FLRD #2 LLC

PHASE II REGIONAL WATER IMPROVEMENTS 0.26 MG POTABLE WATER TANK

FOR PLAN REVIEW

FLRD #2, LLC.
 PHASE II REGIONAL WATER IMPROVEMENTS
 0.26 MG POTABLE WATER TANK
 GENERAL NOTES

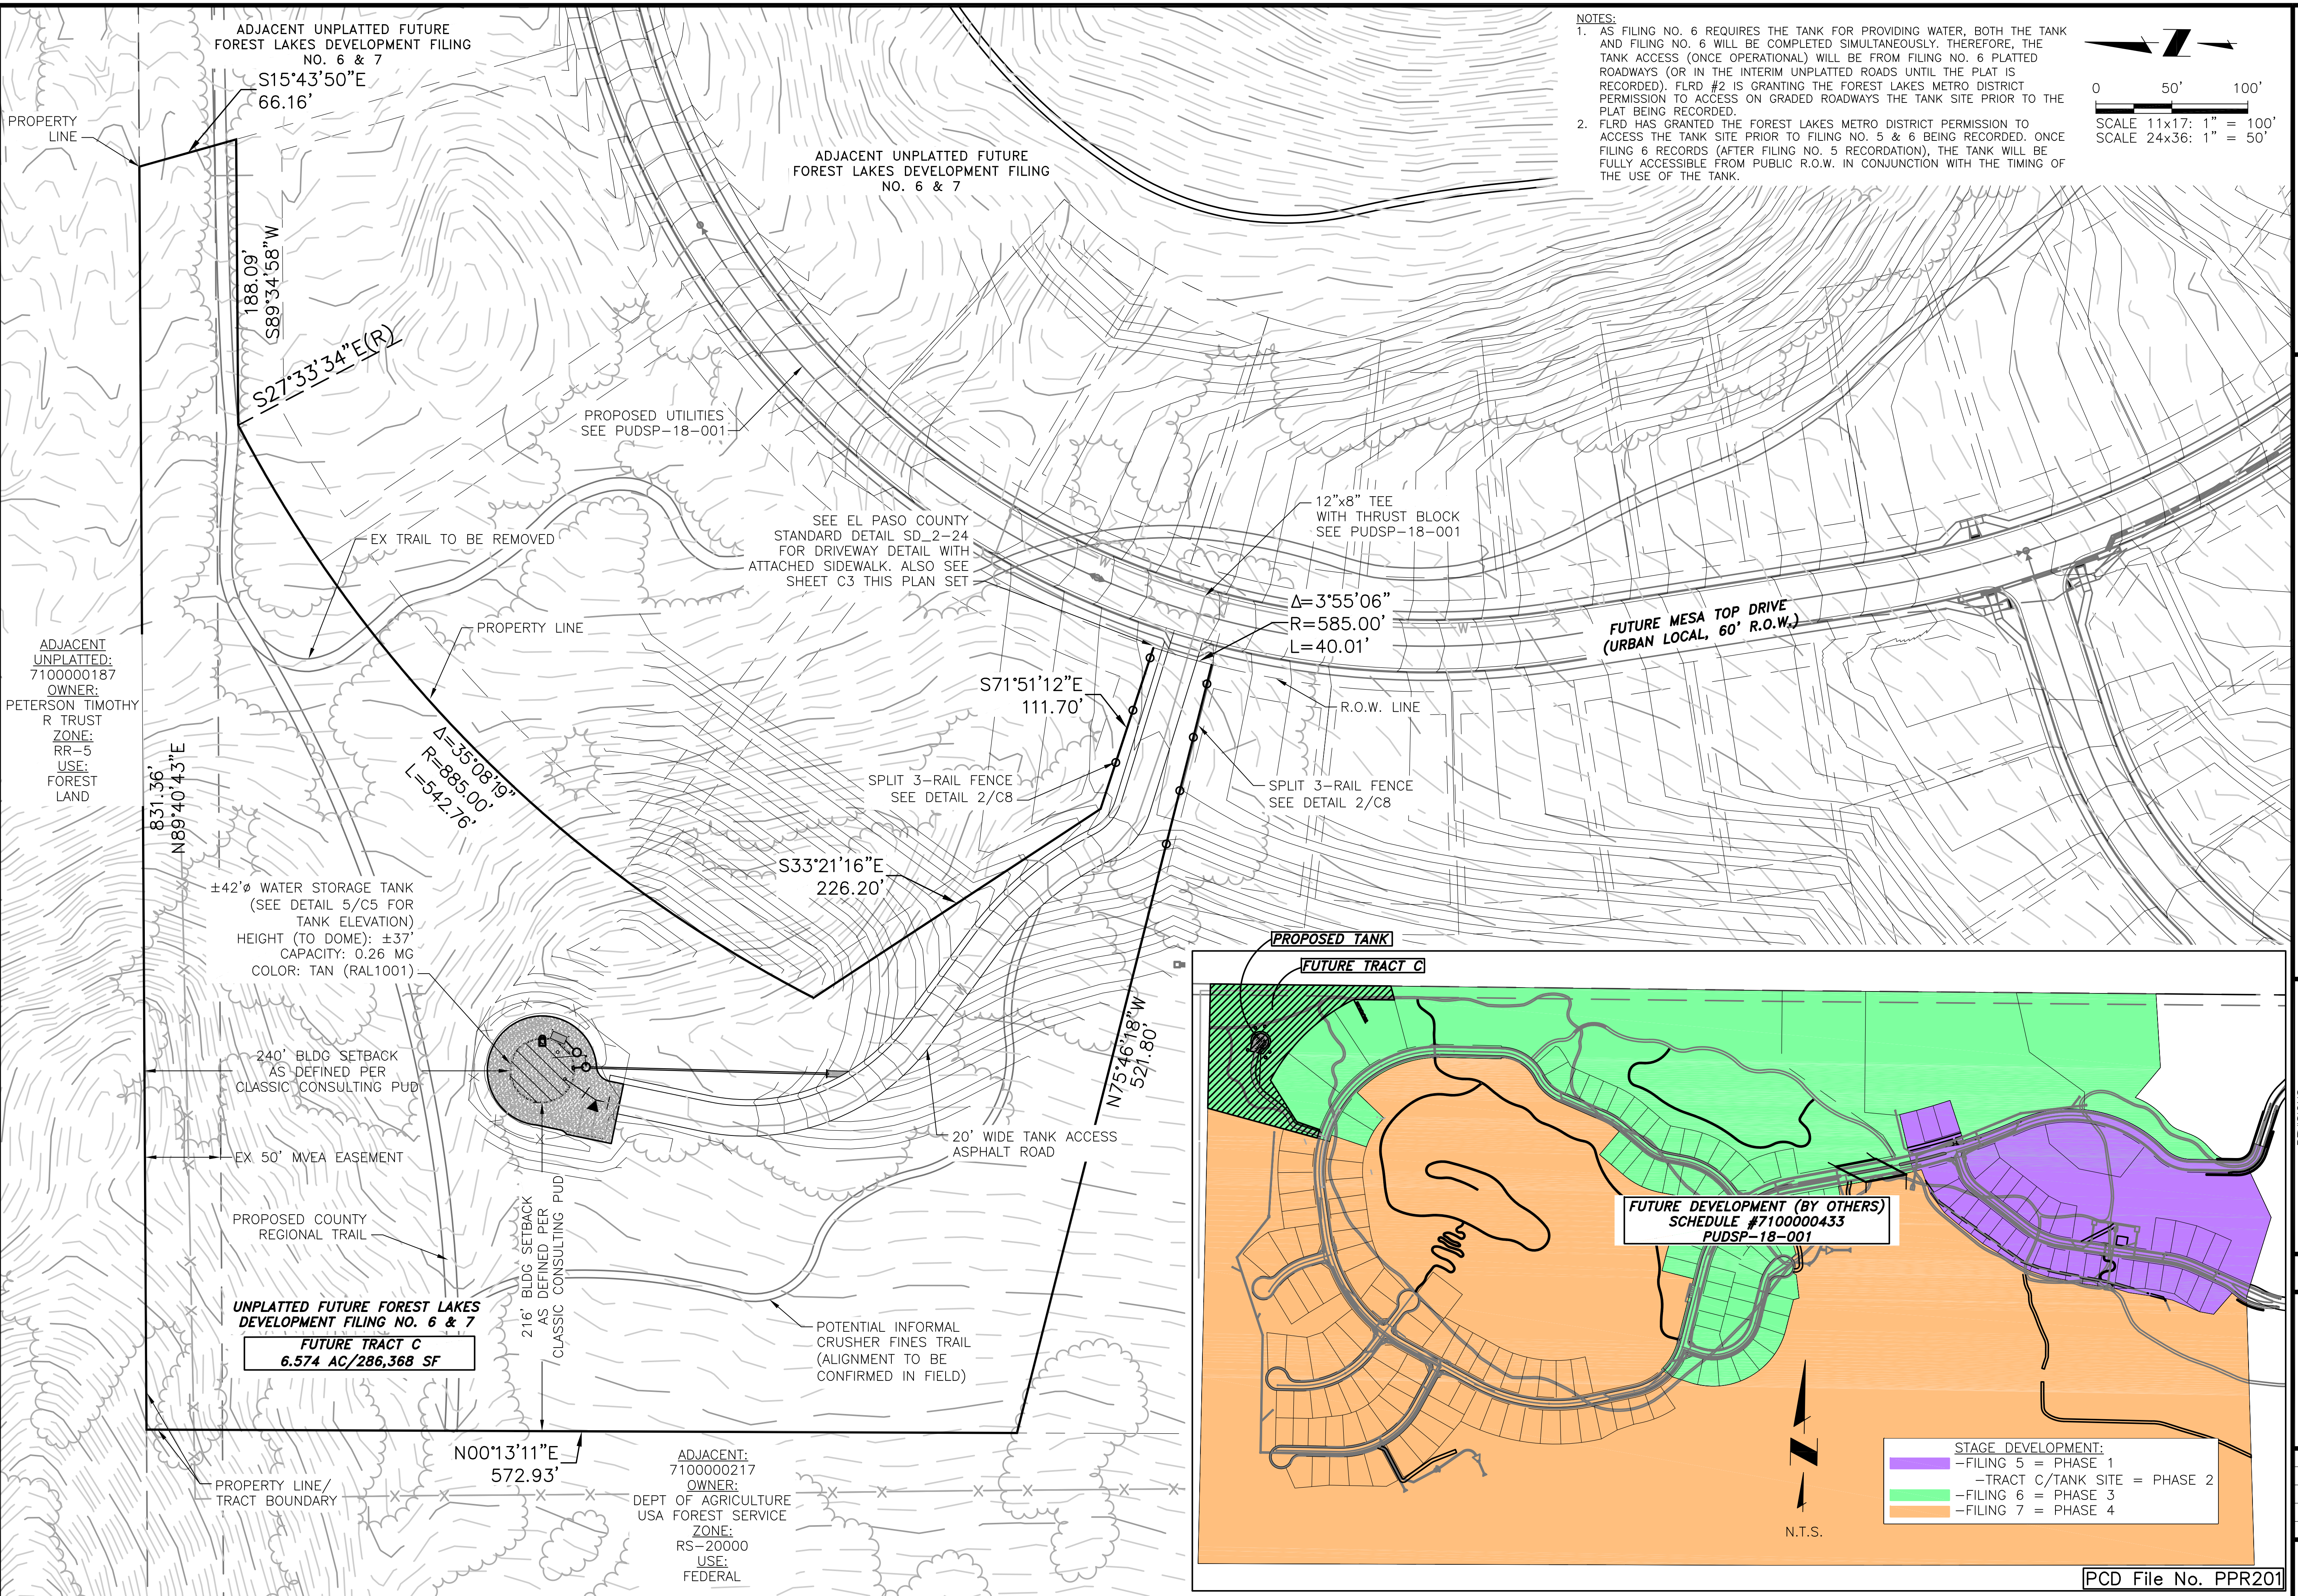
acceptance with a tank site?

Some of these notes seem irrelevant to this project to construct, tank, asphalt driveway, trail, and associated landscape plantings or reseeding

add ADA note

add installation of trail on the site installed by, maintained by XXXX

Are these notes all relative?
